Block 4S – Student Accommodation – Response to Submissions

SSD (SSD-5700-2012)

Solar Access

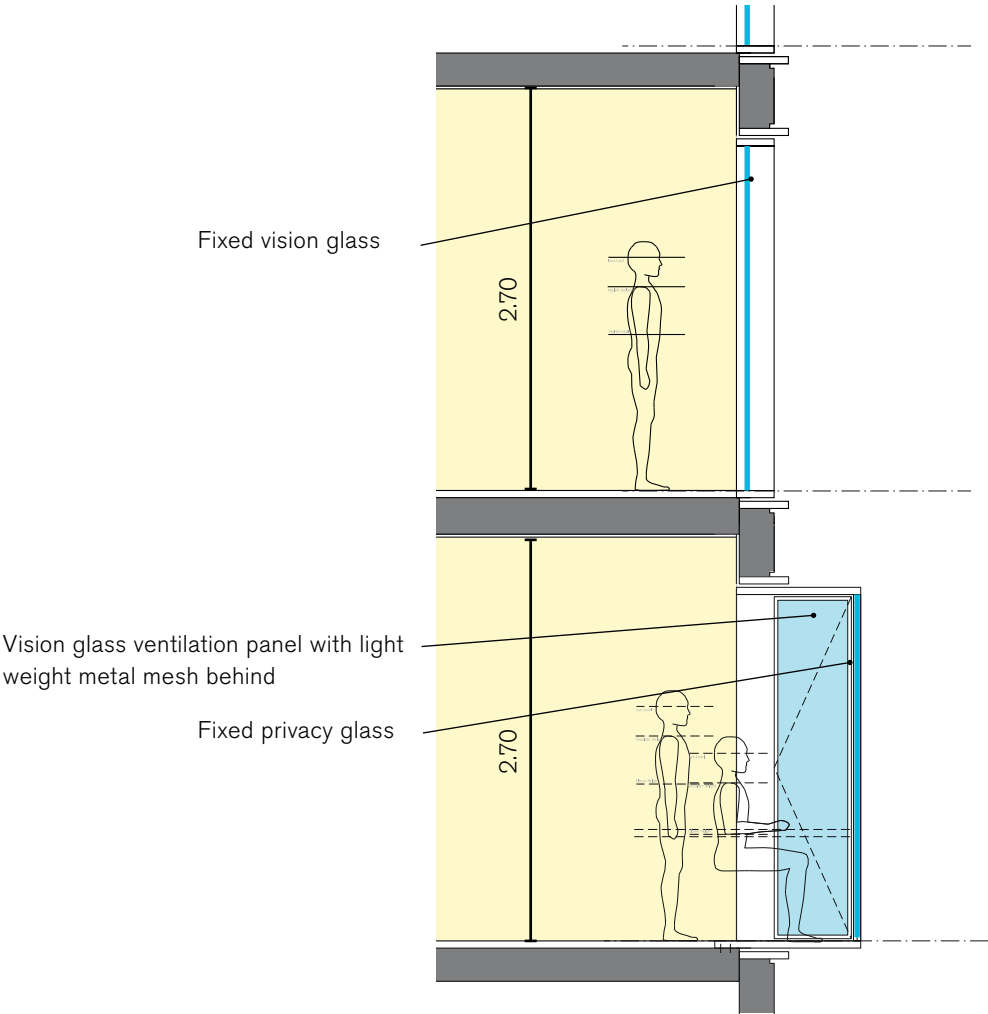
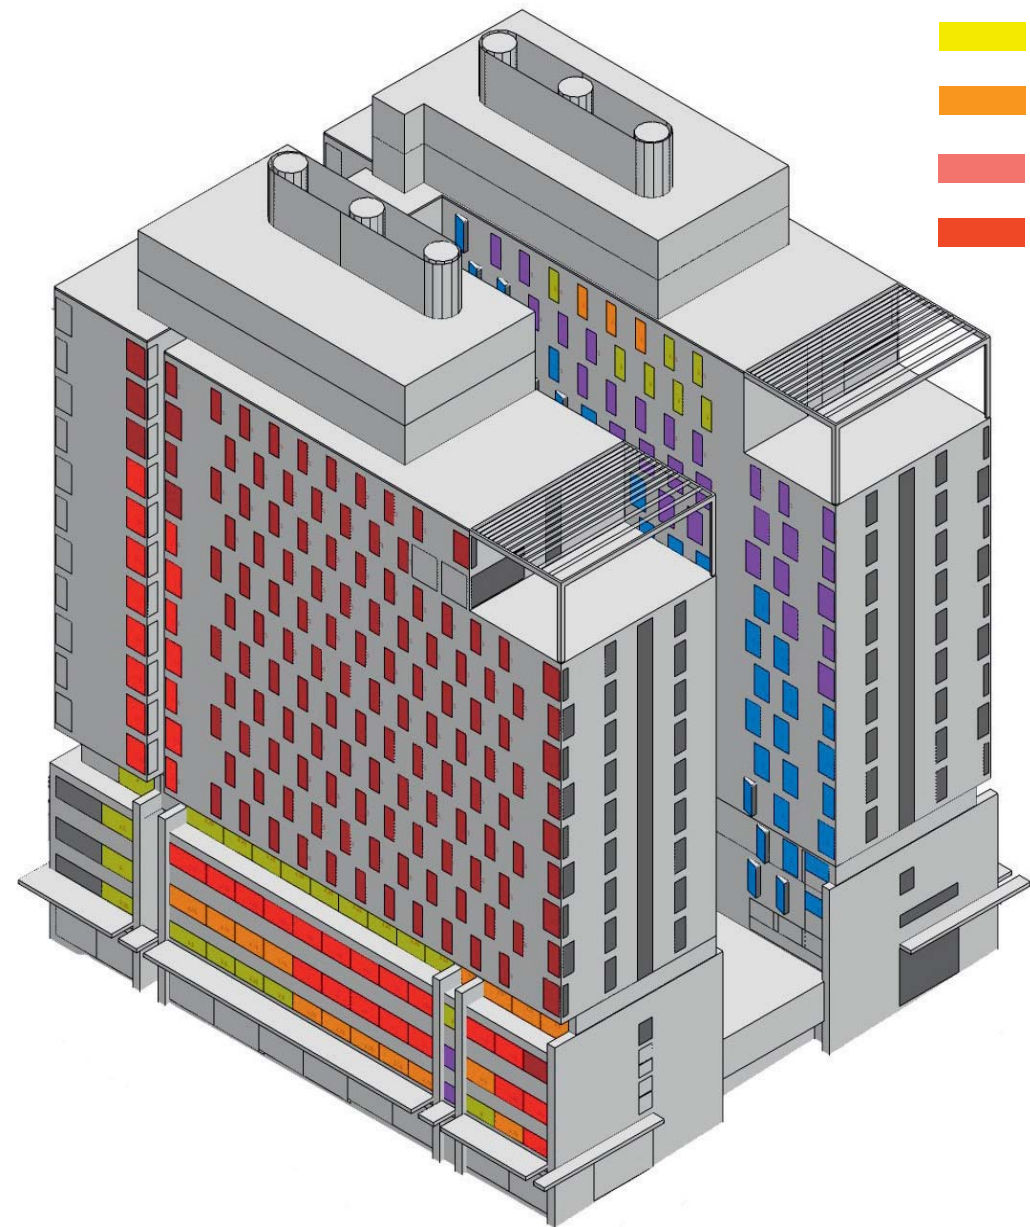
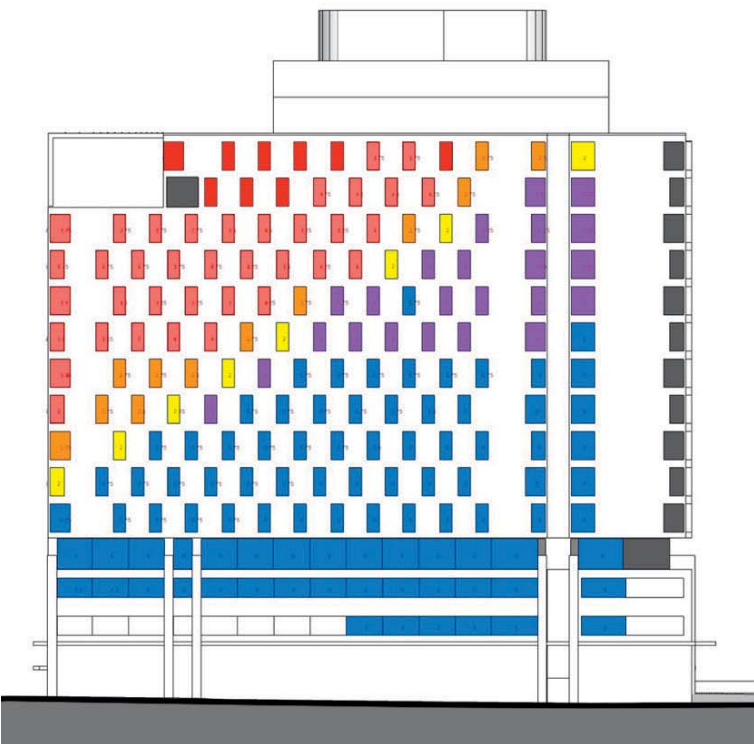
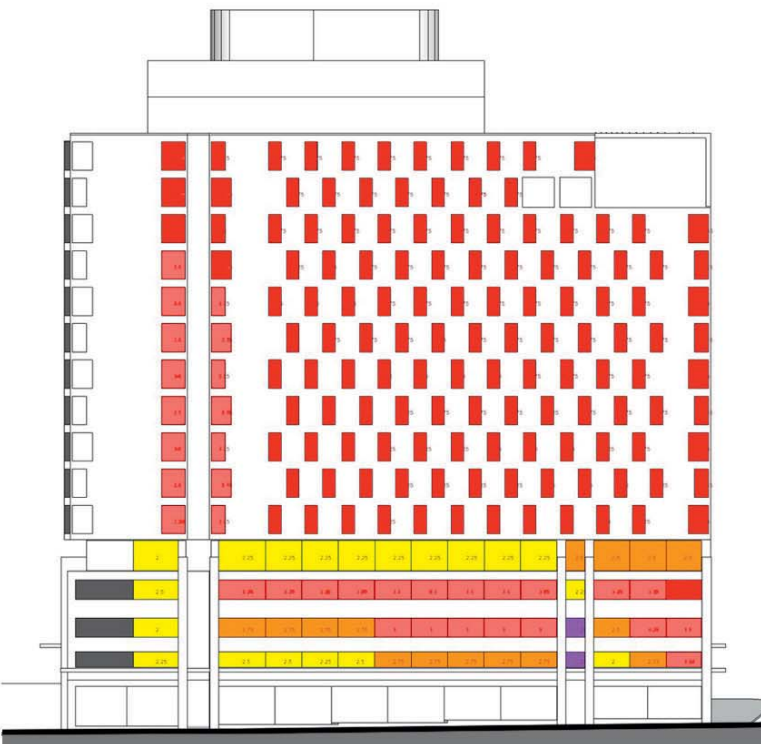
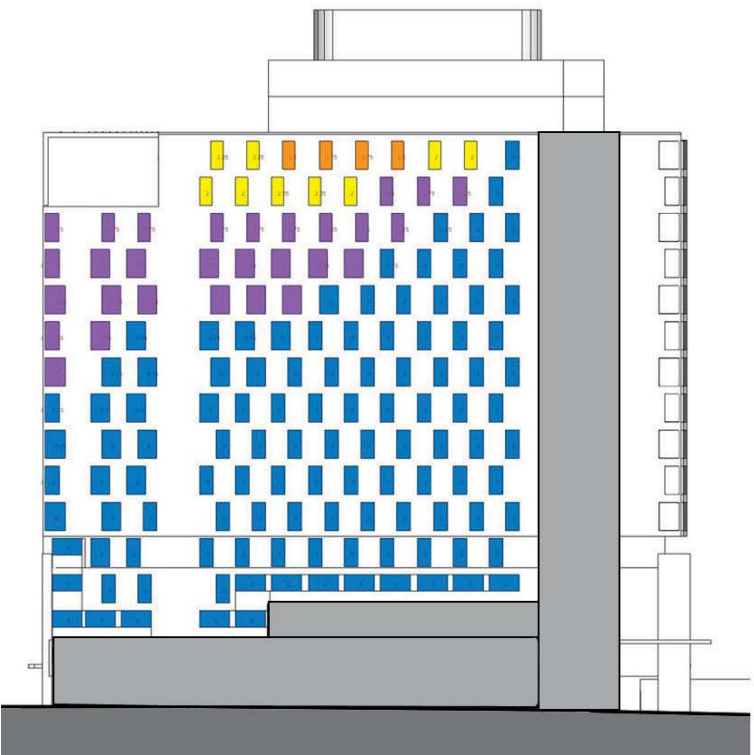
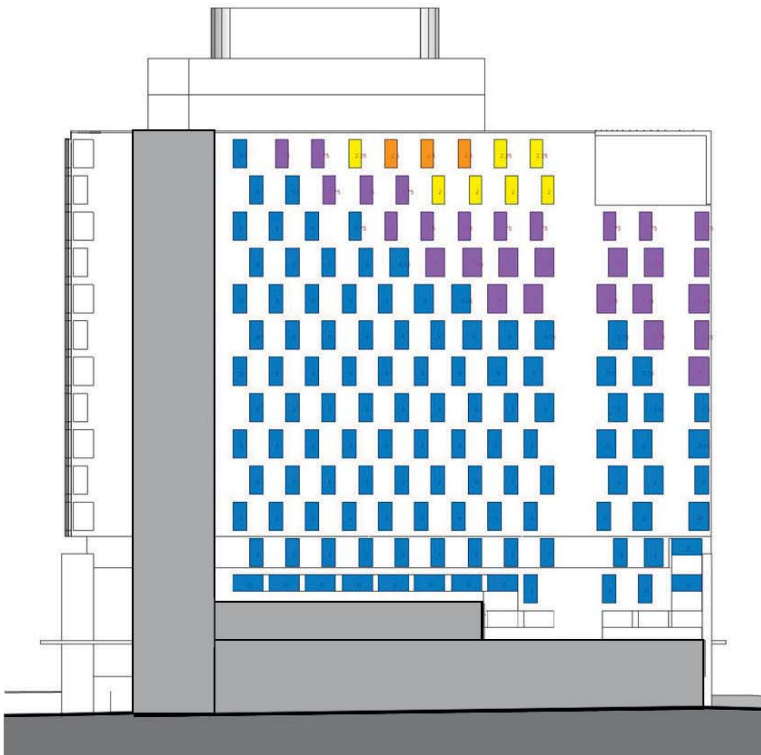
Solar Access	
The City acknowledges the underlying differences in the design and layout of apartments in residential flat buildings and student accommodation. In some instances, the provisions in the Residential Flat Design Code (RFDC) cannot be reasonably achieved and it is more appropriate to consider the merits of a proposal against provisions under Section 4.4 of the Sydney DCP 2012 (SDCP 2012) and the State Environmental Planning Policy (Affordable Rental Housing) 2009 (the SEPP).	Noted. Consideration against the Affordable Rental Housing SEPP has been used as a guide in the consideration of the proposal, layout and relevant development standards.
Although the proposal does not satisfy minimum solar access requirements to internal living areas under the RFDC, solar access to communal living areas throughout the building satisfies the minimum requirements under Clause 29 of the SEPP. The City understands that under the provisions of Clause 29, a consent authority must not to refuse a development that satisfies solar access requirements.	Noted.

The proposal does not result in any significant additional overshadowing to adjacent properties and public open spaces having regard to the extent of overshadowing from surrounding developments. The proposal is generally consistent with the Concept Plan and is considered acceptable.	Noted.
The proposal has demonstrated that adequate natural ventilation will be provided to studios, multi-share apartments, corridors and internal communal open spaces within the building and generally satisfies the objectives of relevant planning controls.	Noted.
Amenity for Occupants	
The proposed typical studio and multi-share apartments provide bathroom and kitchen facilities so the units can be occupied as a separate residence in accordance with the NRAS guidelines. However, the submitted drawings showing the internal layout of rooms are not to scale and it is difficult to determine if the typical room layouts comply with the minimum room size requirements, subject to certain exclusions, under the SEPP (Affordable Rental Housing) and the SDCP 2012.	<p>Details of the typical room dimensions were provided with the original application. These plans have been revised (Appendix A) to reflect to the proposed room layouts (accounting for minor variations to the facades) and have been provided at a scale that allows for calculation of room sizes.</p> <p>The room sizes, dimensions and arrangement have been carefully considered to optimise amenity to the residents within, without having any significant adverse impacts to the amenity of adjoining residents of surrounding land uses.</p> <p>It is noted that the room dimensions, window sizing and arrangement and internal amenity all exceed the required provisions under the DCP and AH SEPP.</p>

## Level 13 - Terrace

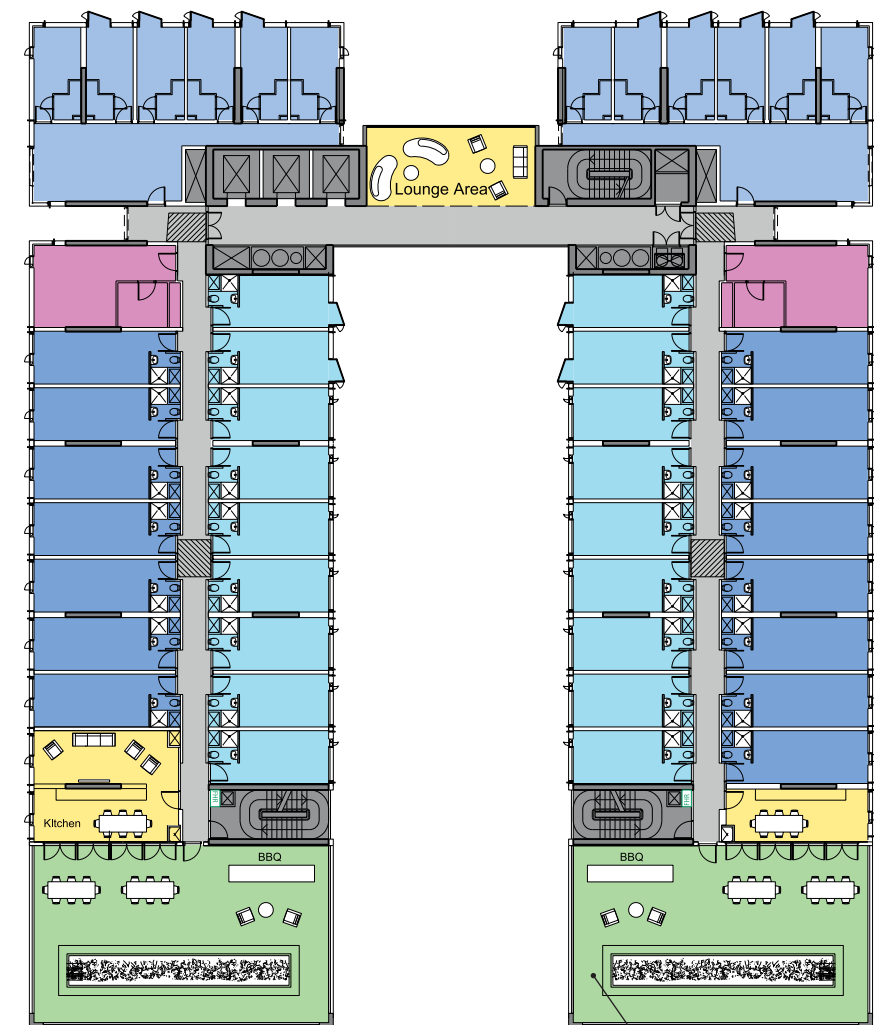
Although there are no specific planning controls that restrict hours of use for outdoor communal area associated with student accommodation, given the scale of the development and density proposed, the City recommends that hours of use of the outdoor terrace on Level 13 be restricted to between 9.00am and 10.00pm, 7 days a week to minimise amenity impacts and disturbances to surrounding residential developments.	The outdoor communal areas within the proposal are to be restricted to be used beyond 10pm in accordance with the recommendation of the acoustic report (Appendix H) and as detailed within the revised plan of management (Appendix E).
It is recommended that a Plan of Management be prepared and submitted to Council for approval upon the selection of a suitable operator and prior to the issue of an Occupation Certificate.	Noted.
Community Concerns	
Council officers have been contacted by some members of the local community who have raised concerns regarding the subject proposals. The City has been advised that individual submissions will be prepared and submitted to the Department for consideration.	Noted. These submissions have been addressed, by issue, in the public submission table.

**Studio Long**

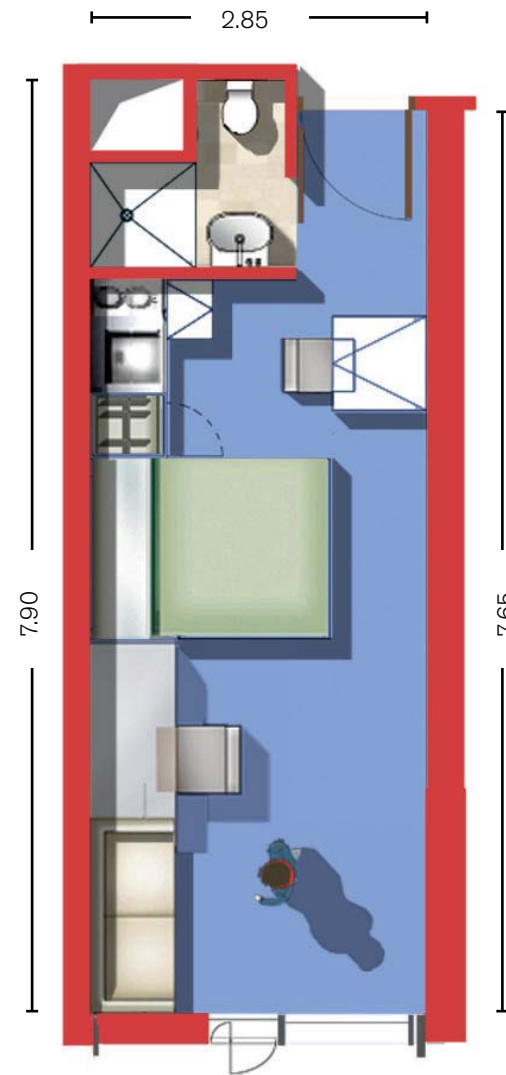
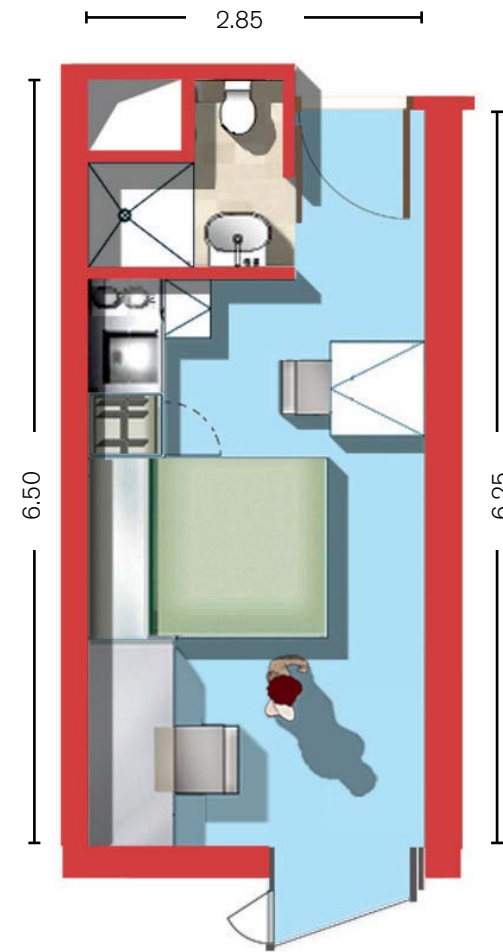
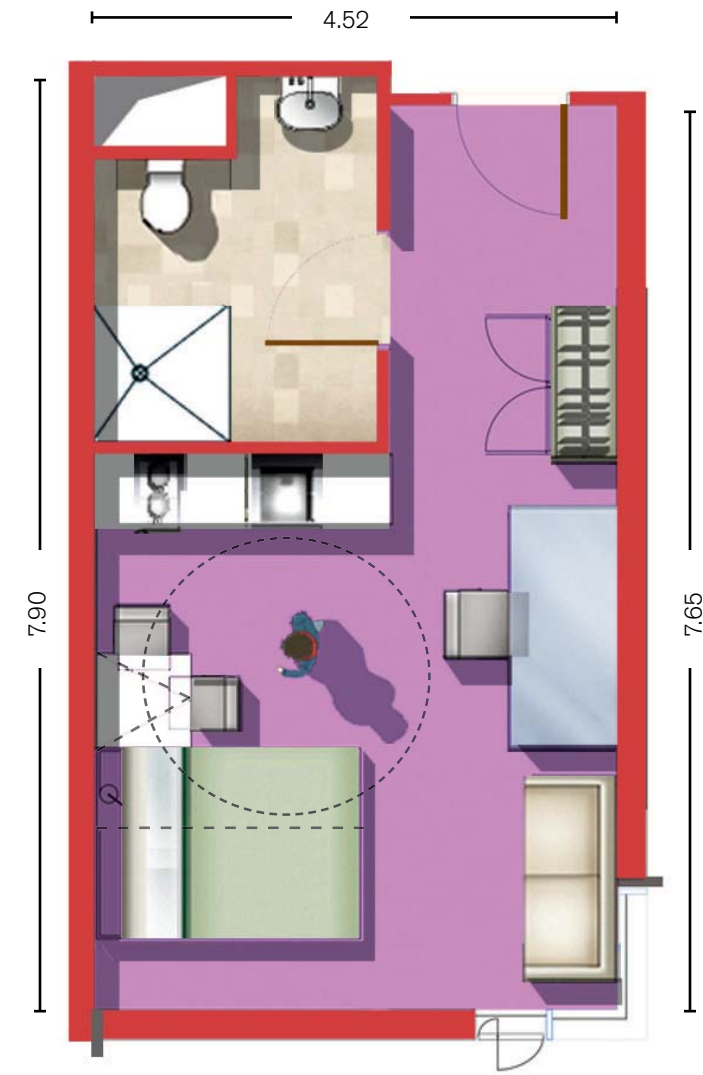
To ensure that the proposed rooms provide adequate amenity and satisfy provisions under the SEPP and the SDCP, it is recommended that a condition be imposed requiring minimum room sizes in accordance with Clause 29 of the SEPP and	The proposed plans provided (Appendix A) are considered suitable to ensure the appropriate room dimensions. The proposed dimensions exceed the minimum

City of Sydney - Recommended Conditions	
<p>(3) MINIMUM ROOM SIZE FOR STUDIOS</p> <p>a) The minimum room size for a standard studio must not be less than 18.9m².</p> <p>b) The minimum room size for a long studio must not be less than 22.2m².</p> <p>c) The minimum room size for a deluxe/accessible studio must not be less than 34.5m².</p>	<p>It is proposed for this condition to be removed given the architectural plans reflect the proposed room sizes (see Appendix A)</p>
<p>(5) LAUNDRY FACILITIES</p> <p>a) Laundry facilities, including laundry tubs, washing machines and dryers are to be provided in accordance with the Clause 4.4.1.5(2) and (3) of the Sydney Development Control Plan 2012.</p> <p>b) Fit out details of the communal laundry on Level 1 are to be submitted to Council for approval prior to the issue of a Construction Certificate.</p>	<p>See Section 2.6 of the RTS. for further discussion</p> <p>It is proposed for this condition to be removed given the proposed arrangement of washing machines to suit specific, professionally managed student accommodation.</p> <p>and details provided in on the revised architectural plans (Appendix A)</p>

Clauses 3.12 and 4.4.1 of the DCP.	<p>requirements of the AHSEPP as well as the relevant DCP requirement of the Central Sydney Control (that are not directly applicable to the proposed).</p> <p>It is proposed to delete condition 3 of the recommended conditions, given the detail provided on the plans that will form part of the instrument that would adequately ensure the minimum room dimensions.</p>
Internal and external communal open spaces satisfy the provisions under the SDCP 2012 and the SEPP (Affordable Rental Housing) 2009.	Noted.
The fit out of the communal laundry on Level 1 have not been provided. A condition is recommended to require the provision of adequate laundry tubs, washing machines and dryers in accordance with the SDCP 2012.	Refer to Section 2.6 of the RTS for discussion. The fitout of the communal laundry has been provided within the revised architectural plans (Appendix B)
